Fermoy Housing Development at Cork Rd, Fermoy Co. Cork

Stage 1 Road Safety Audit

January 2022

Client	Cumnor Construction
Project Title	Fermoy Housing Development
Document Title	Report for Stage 1 – Road Safety Audit
Job No.	19099TT
Document No.	19099TT-Doc05

Drawing Title: Stopping Sight Distance
Sheet 1 of 2

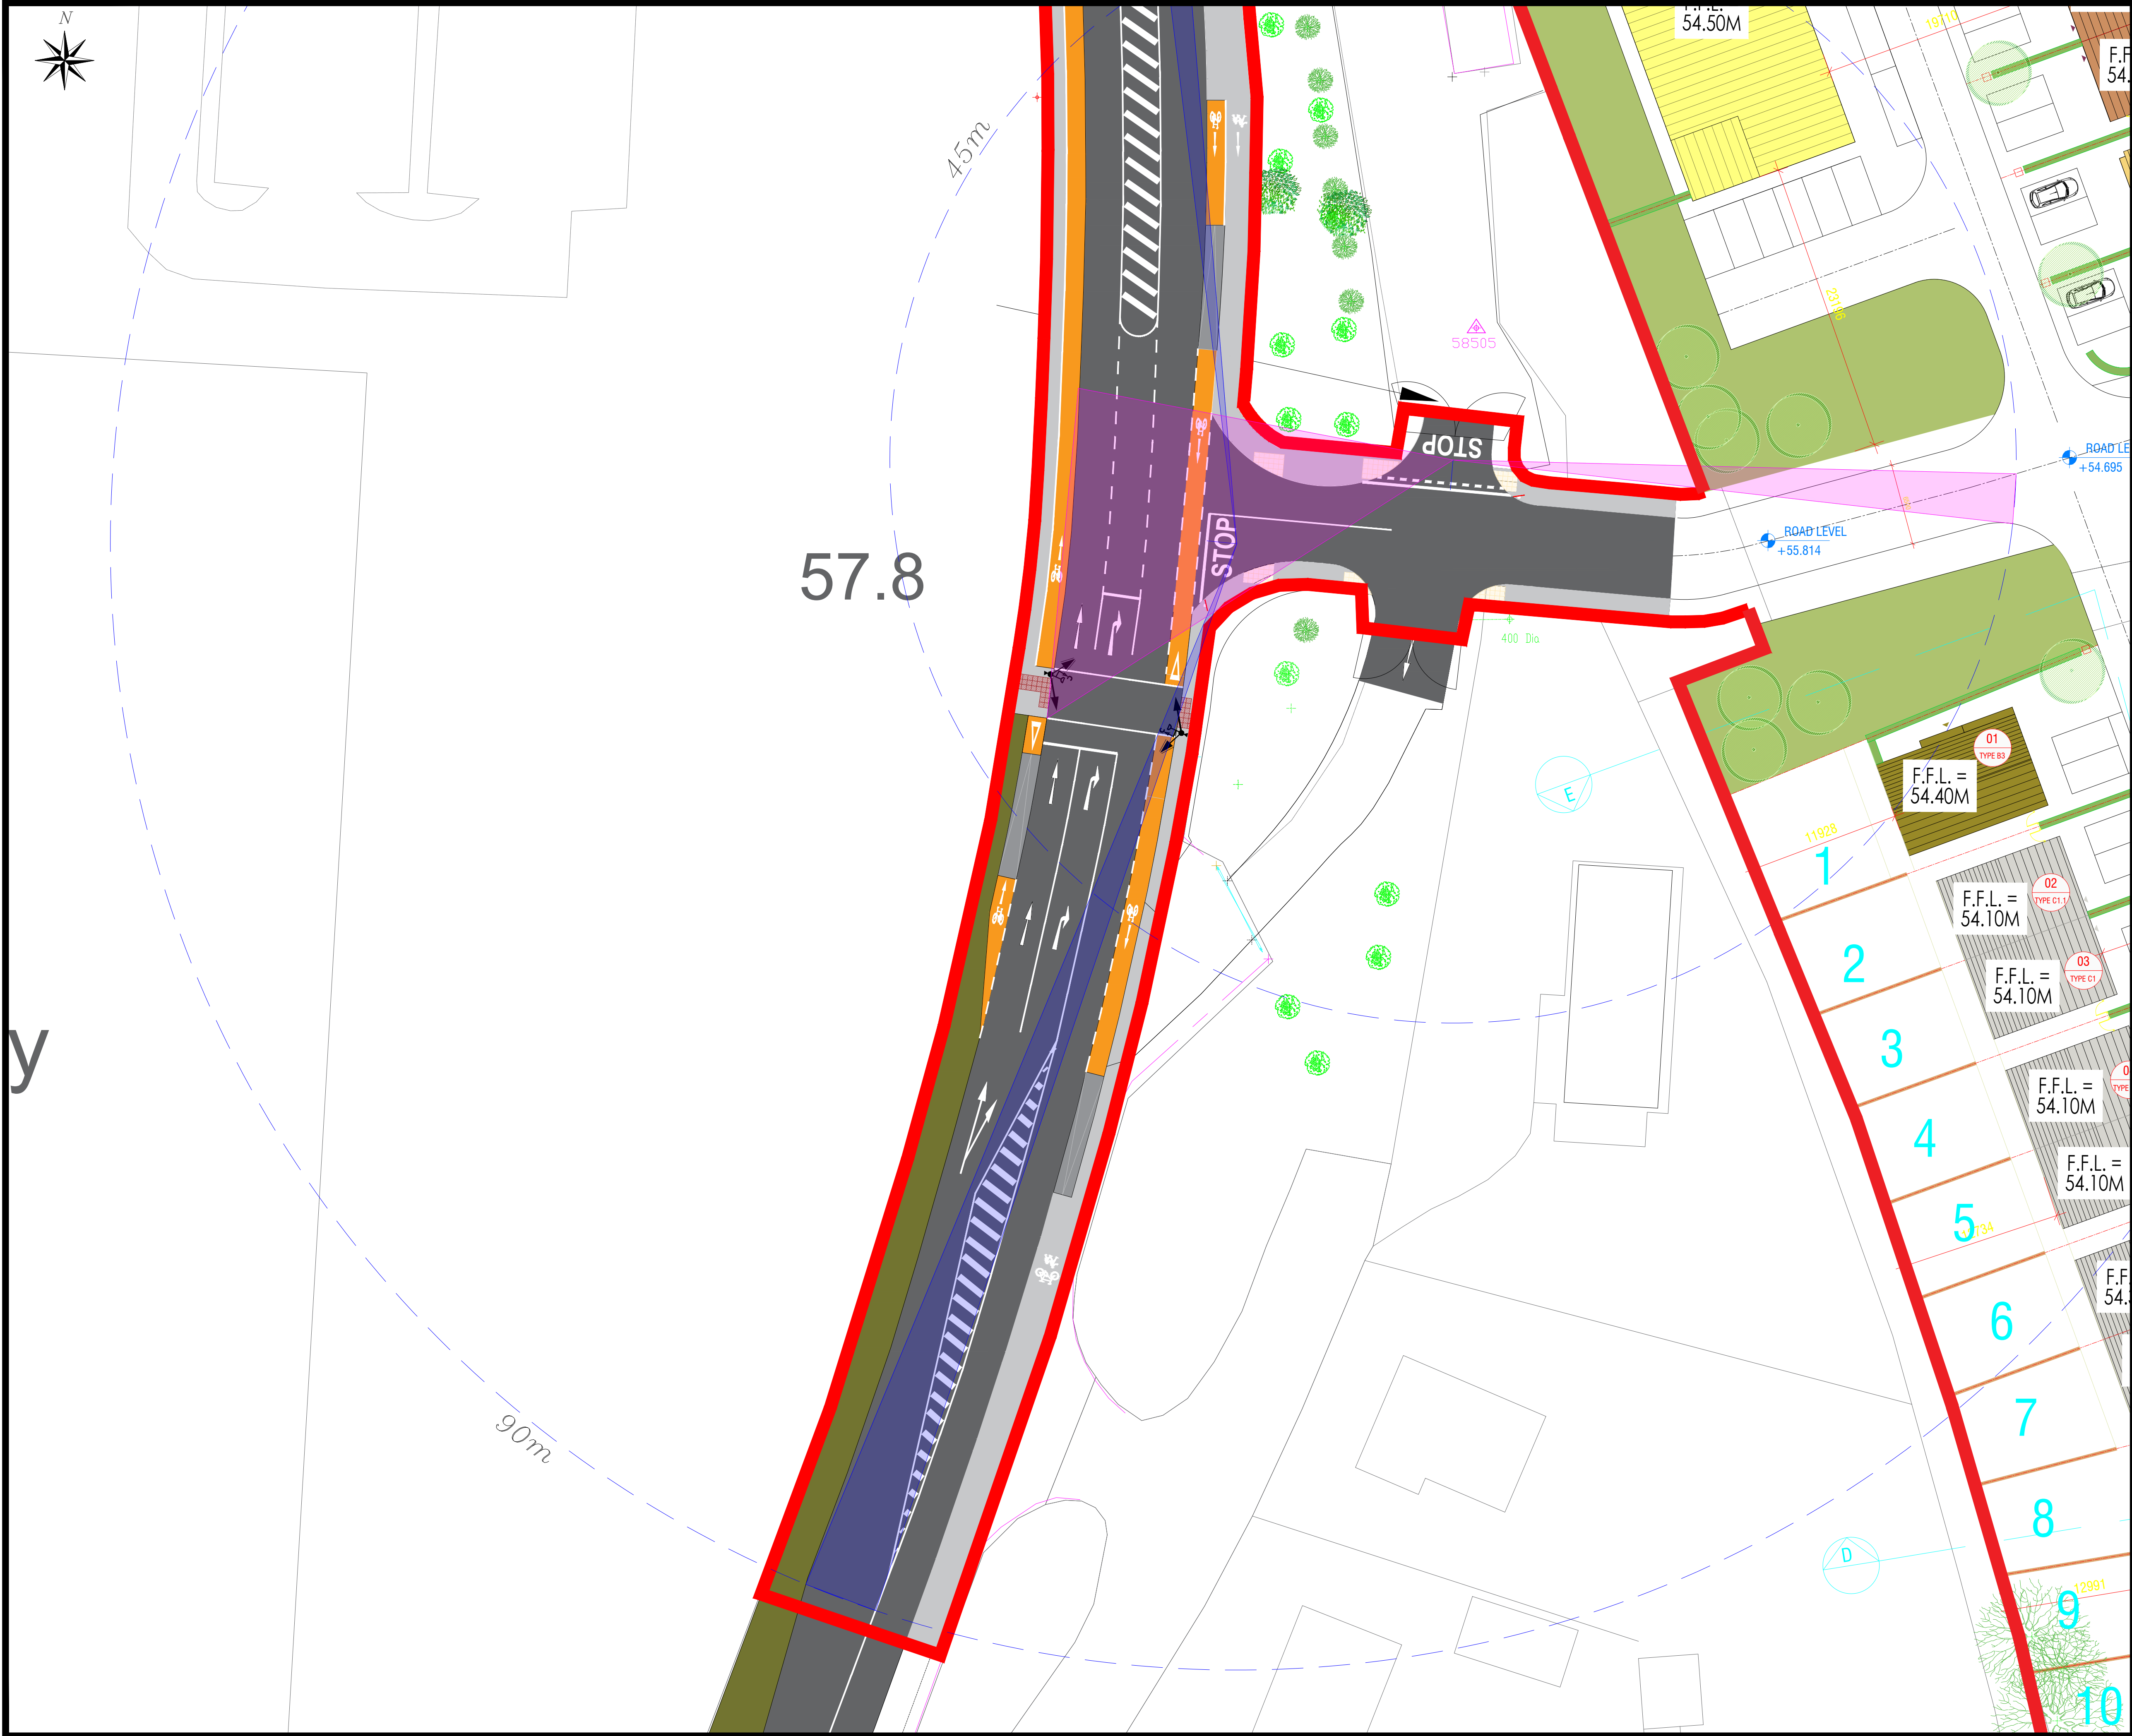
The proposed cycle lane as shown in Figure 2.1 could create confusion between pedestrian and cyclists at this locations. Failure to provide consistent and a streamlined design could lead to collisions and conflict between pedestrians and cyclist travelling in various directions. See Figure 2.1.

Specific details of the proposed tactile paving and dropped kerbs at a number of locations have not been shown on the drawings provided to the audit team. Failure to provide an appropriate crossing point with tactile paving may lead to collision between pedestrians, visually impaired users and vehicles entering and exiting the Side roads. See Figure 2.2 & 2.3.

No details have been provided as to how cyclist will join and exit the proposed cyclelane to the south of the junction. Inadequate details at these locations could lead to collisions between cyclists and vehicles along R639. Refer to Figure 2.4

It is proposed to terminate the proposed footpath to the south of the proposed signalised pedestrian crossing on the western side of R639. This could lead to confusion for pedestrians and could cause collisions between pedestrians crossing the road at footpath end and vehicles travelling on the R639. Refer to Figure 2.5

Some of the road marking and signage details have not been provided at the junction onto the regional road and at the right-hand turn lane. Inadequate road marking and signage could lead to collisions between vehicles and pedestrians using the proposed development.

As there are no cycling facilities proposed as part of the development, the design team should consider providing a shared facility at this location.

Provide the appropriate tactile paving at all locations in accordance with the relevant guidelines.

Provide connection details between the proposed cycle lanes and the R639

The designed should look at the proposed termination point of the footpath.

Provide adequate Signing and Lining at the junction with the R639. All signs should be located outside of sightline splays area.

2.1	Yes	Yes		
2.2	Yes	Yes		
2.3	Yes	Yes		
2.4	Yes	No	Proposed toucan crossing will be moved to the south of the development entrance junction and link into this length of footpath.	Yes
